Our Case Number: ABP-322166-25

Re: Proposed residential development for Corrib Causeway, Dyke Road
Corrib Causeway, Dyke Road, County Galway

Our Ref: 91.08/25

RE: Invitation to Submit Observation on Applicants Response to Observations at Corrib Causeway, Dyke Road, County Galway. ACP File Ref ABP-322166-25.

PROPOSED ROAD LAYOUT
(SHEET 01)

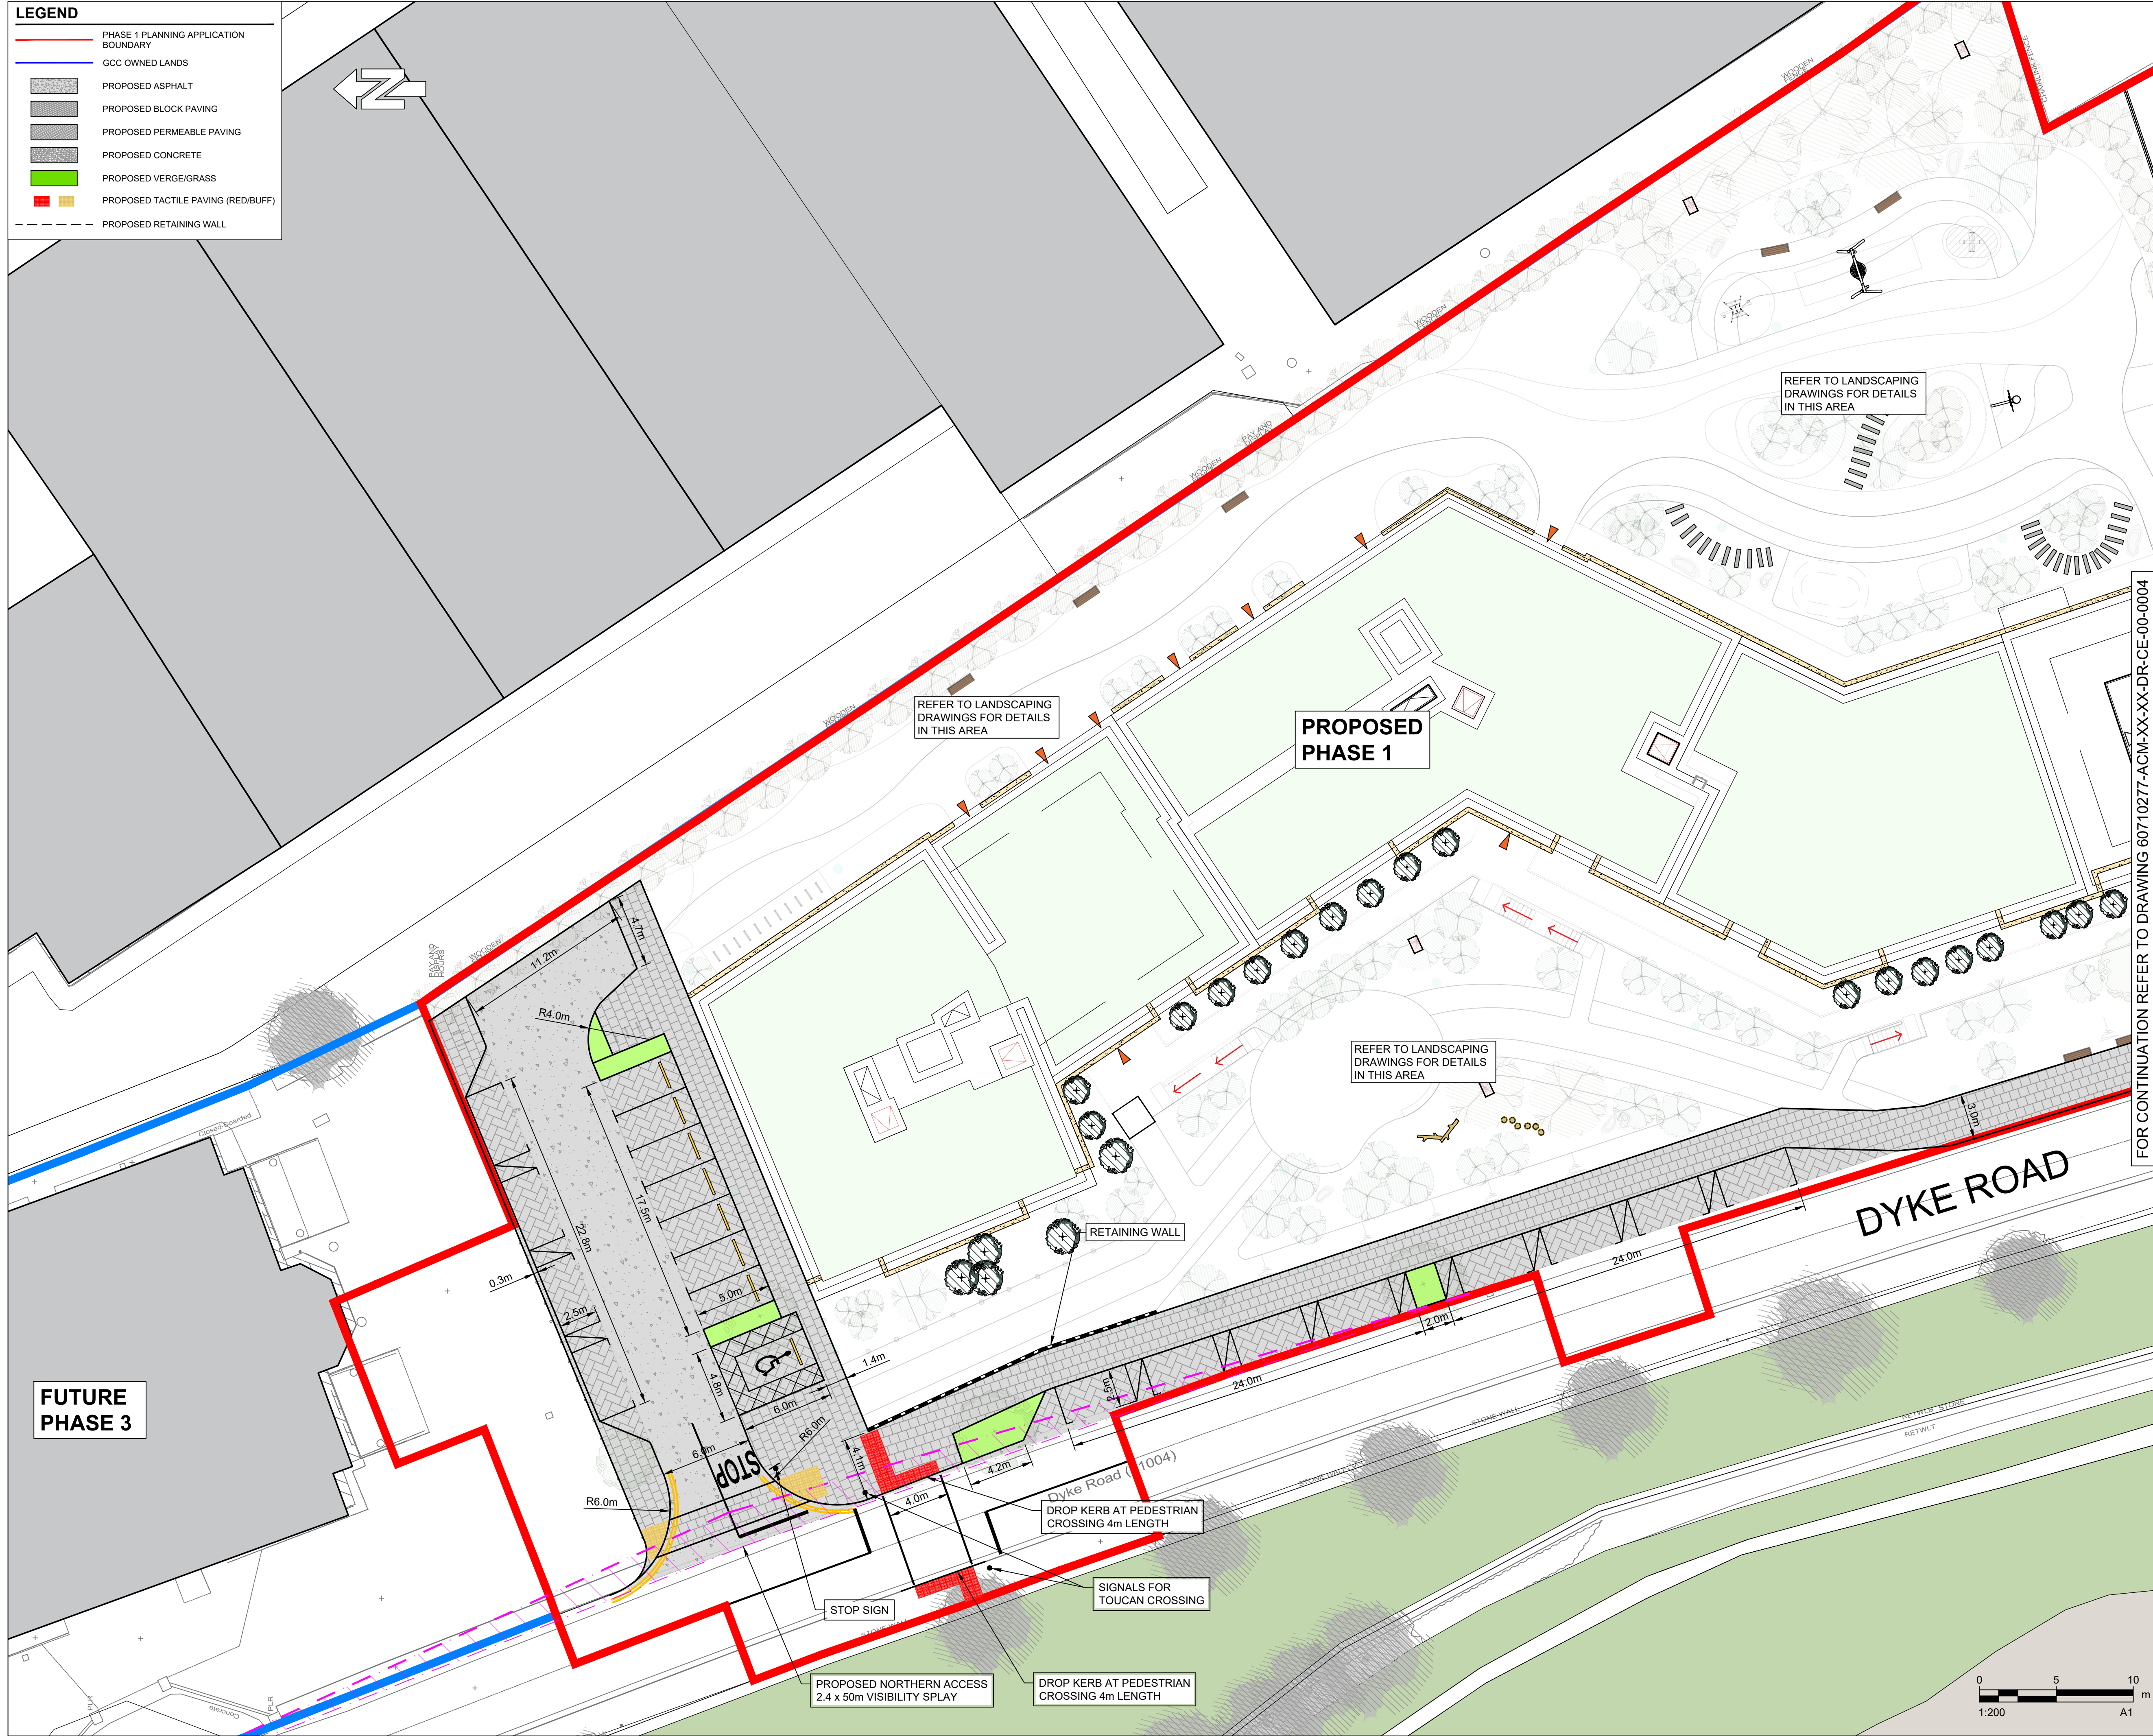
The proposed development includes the removal of 389 no. of the existing 511 no. car parking spaces neighbouring the retail park. The proposal also includes 33 no. car parking spaces for the proposed residential units.

The combined maximum carpark use on the weekend date surveyed was 350 no. spaces of the 511 no. spaces available. The proposed development includes the removal of 389 no. car parking spaces resulting in only 122 no. car parking spaces remaining on the site. As such, there is a clear under-provision of car parking remaining on the site to provide for the existing day-to-day demand. This also does not take in to account the significant demand for car parking increasing during peak periods such as December.

Additionally, the proposed development proposes only 33 no. car parking spaces for the 219 no. proposed residential units. While a move towards reduced car parking in residential developments is acknowledged, it is considered that a provision of 0.15 car parking spaces per unit is unacceptably low. This is an unacceptably low provision in relation to the subject residential development proposal for a number of reasons including the substantial removal of existing car parking spaces which are in demand and also the location of the proposed development directly neighbouring an existing retail park where many of the existing retailers are bulky goods stores for which the availability of car parking is essential.

It is unclear how the applicant has arrived at this conclusion. The existing demand within the retail park car park was not included within the traffic survey undertaken by PUNCH Consulting Engineers and the car parks that were included in the survey show greater car parking space usage than the number of spaces remaining should the proposed development proceed (350 no. of 511 no. spaces in use at one time during weekend survey and only 122 no. spaces to remain after development). Given

The loss of the proposed 389 no. car parking spaces poses a serious risk of creating an overflow situation, where the reduced capacity of the car park could lead to parking difficulties for the retail park's customers. This overflow could disrupt customer access to businesses within the retail park, potentially leading to a decline in footfall and, consequently, a negative impact on the revenue of the businesses operating there.
